About the application

Application number: 2023/91109	
What is the application for?:	Erection of first floor extension and extension to garage roof
Address of the site or building:	54, Knowl Road, Mirfield, WF14 8DL
Postcode:	WF14 8DL

Type of comment: An objection	
Do you wish your comments to be published on the website anonymously?	Yes

**PROPOSED NORTH EAST
ELEVATION SCALE 1:50**

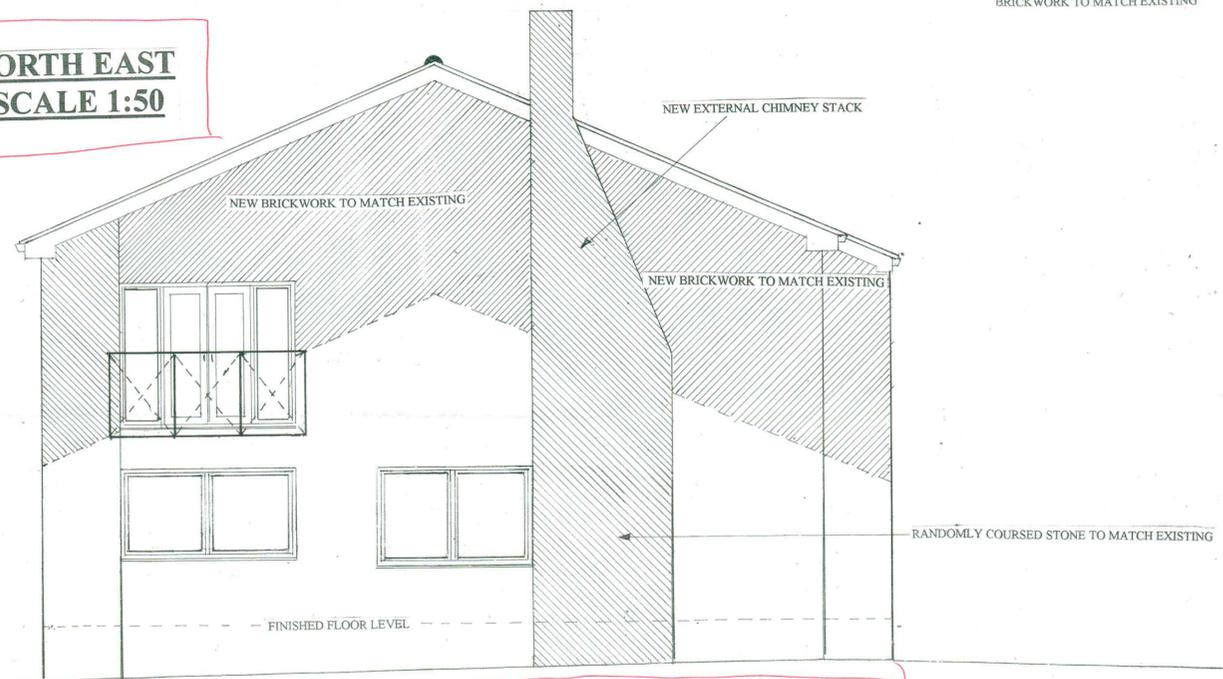
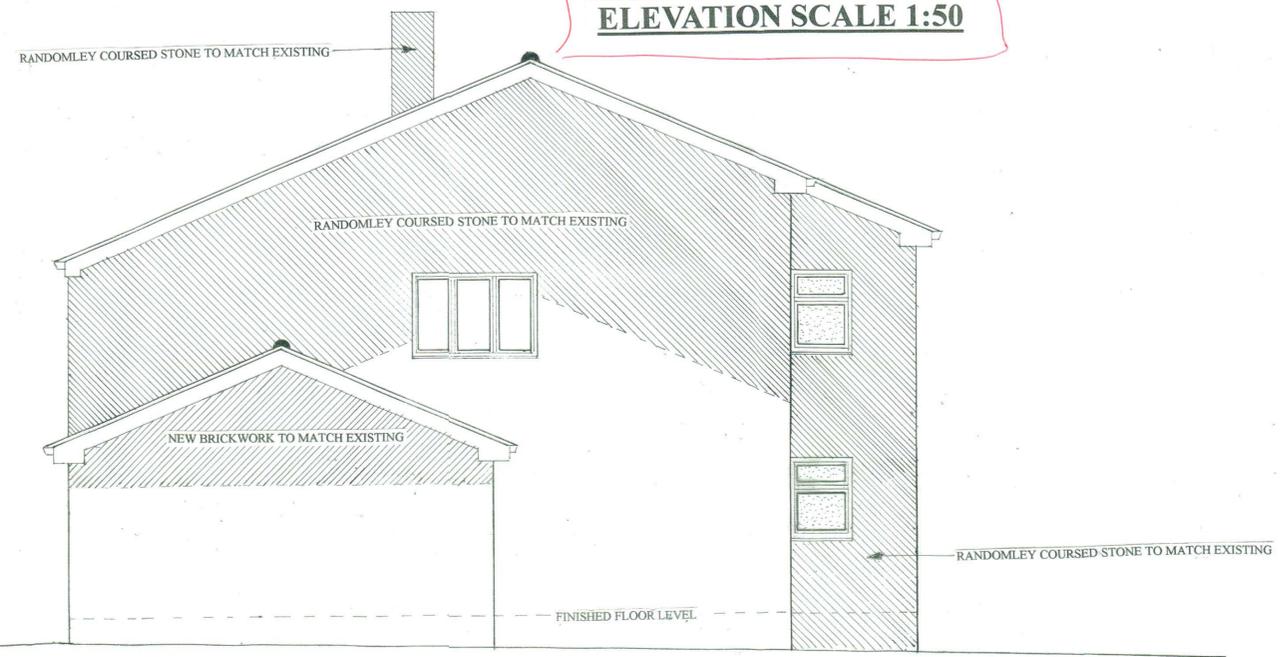
The proposed design and appearance of the property is extremely unattractive. Simply building up from the existing structure will look unsightly. Brick on top of existing 'random' stone at the front, with a blank 1st floor brick wall at the side of the next door bungalow will be an eye sore and will block easterly light to their home and garden. All the nearby properties, those sharing the drive and those along the footpath to the side of this property are extremely attractive in design, and built of solid Yorkshire stone. This property is not in keeping with any of the others, and will "stand out like a sore thumb" if this application is allowed to proceed.
